KITTITAS COUNTY DEPARTMENT OF PUBLIC WORKS

Re: Forest Ridge Phase 1 – Final Plat Application

Recently, a Final Plat Application was submitted to the County for the above subject project. Upon review, the final plat is incomplete and is recommended to remove the application until the deficiencies outlined below are addressed. The items below reference Kittitas County Road and Bridge Standards, 2005 edition.

CREEKSIDE ROAD & FOREST RIDGE DRIVE
IRON SNOWSHOE, LLC
CREEKSIDE ROAD
PLAN AND PROFILE

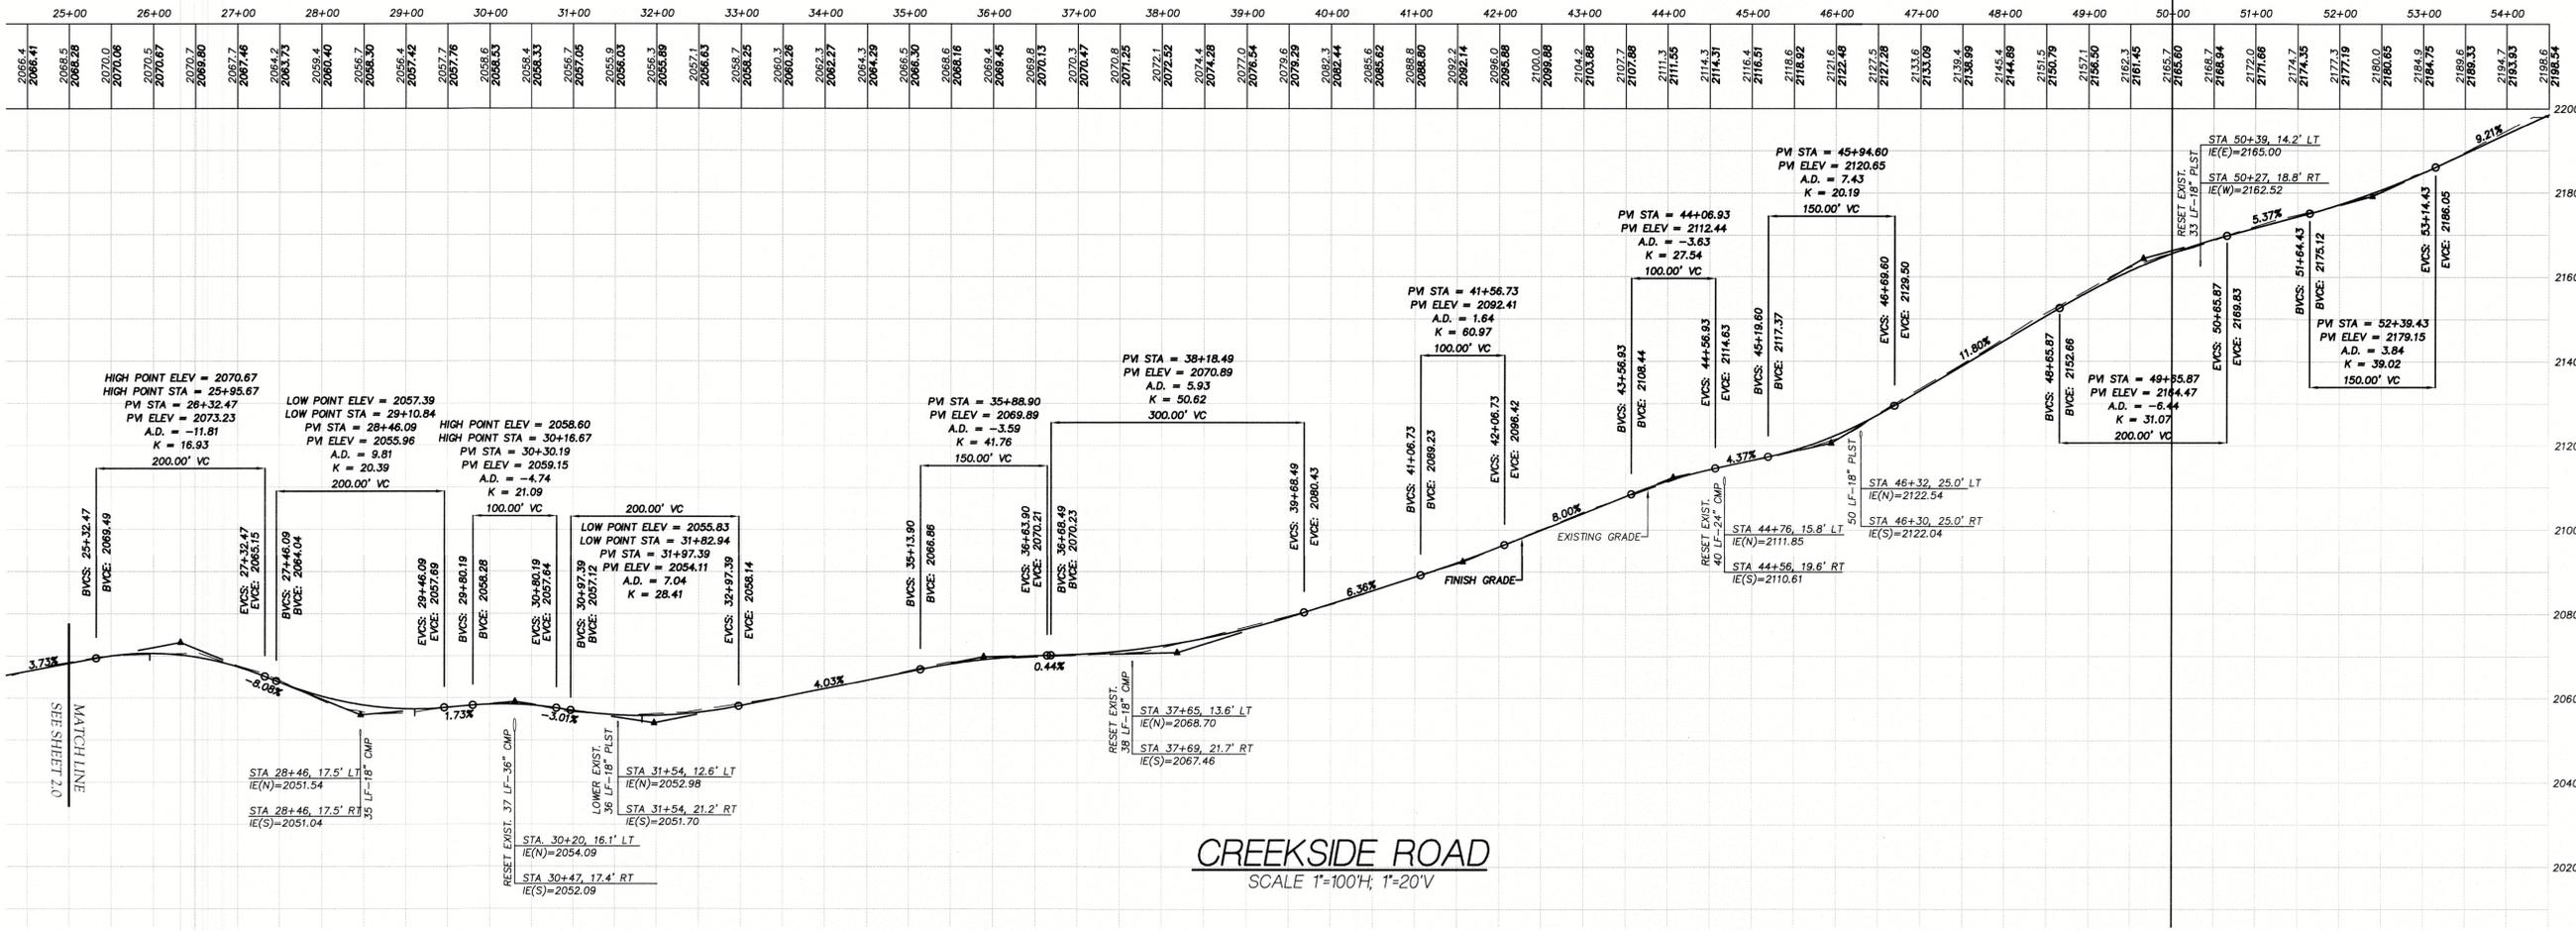
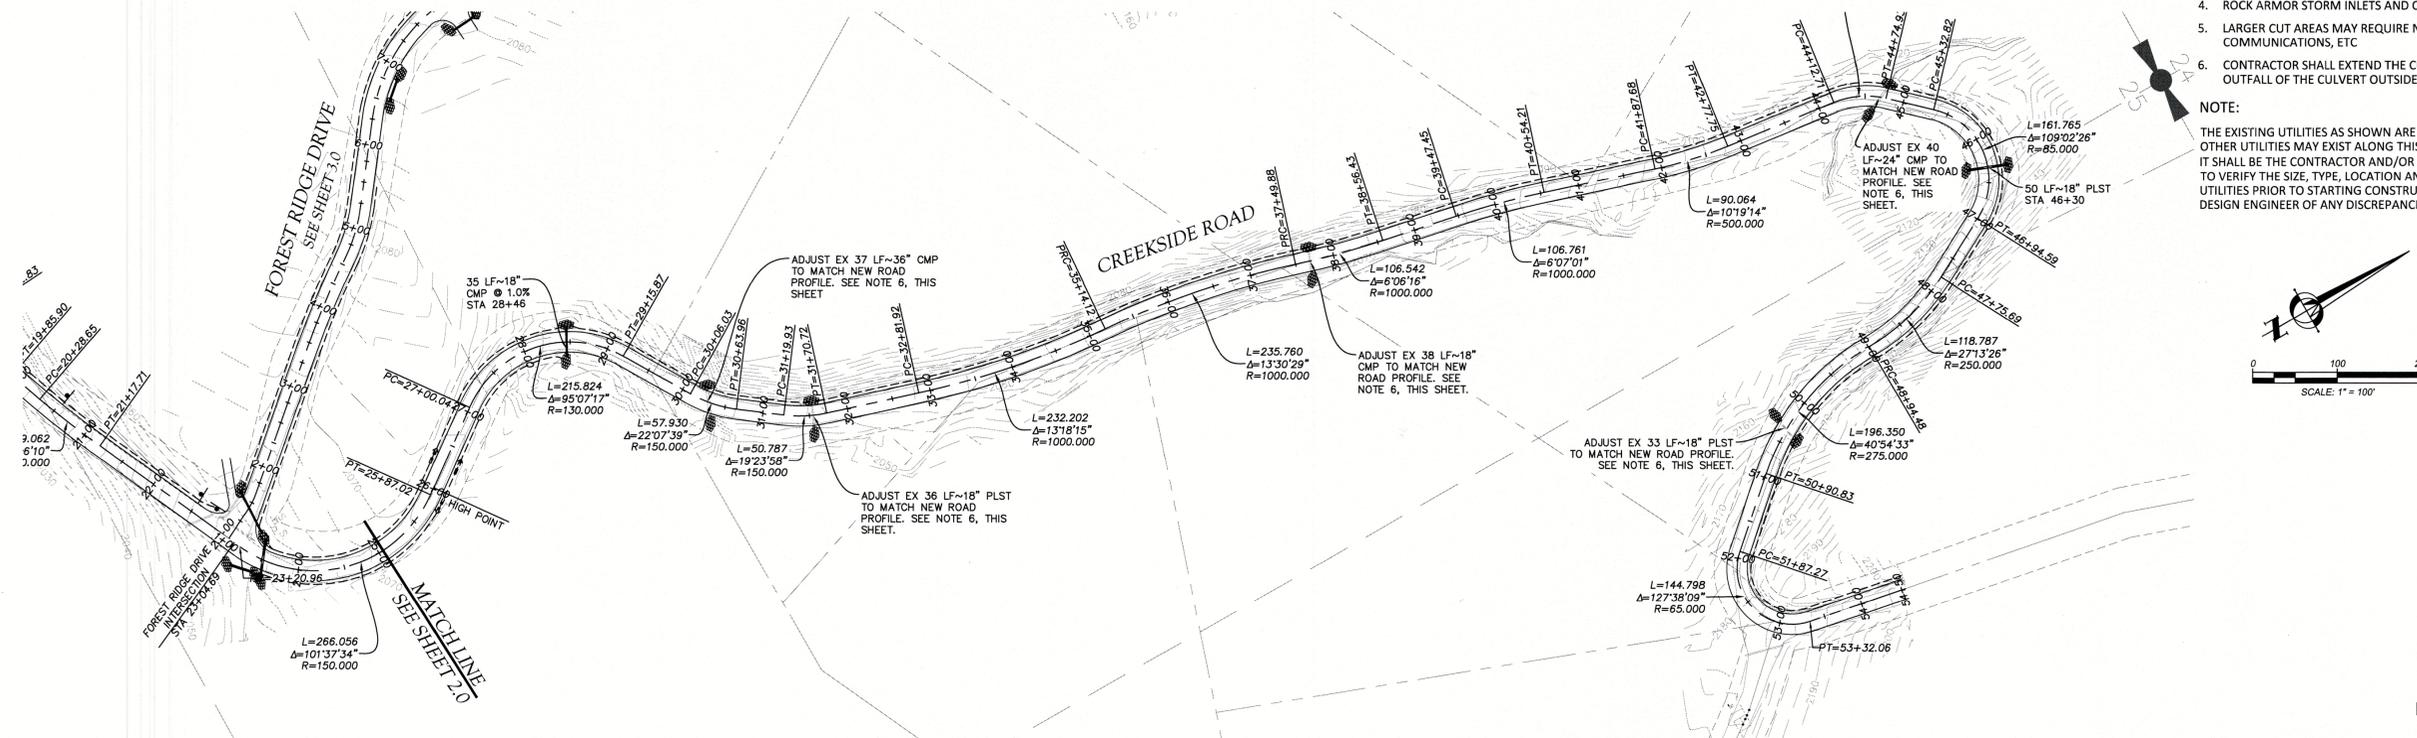
1. Road Certification is required for all private roadways (12.12.010).
2. Roadway width is to be two 11-foot lanes with 1-foot paved shoulders for an overall roadway width of 24 feet (Figure 12-2).
3. Maximum road grade is 12% (Table 12-1).
4. Approval of a stormwater drainage report has not yet been finalized.
5. Known stormwater issues, including discharging to new locations.
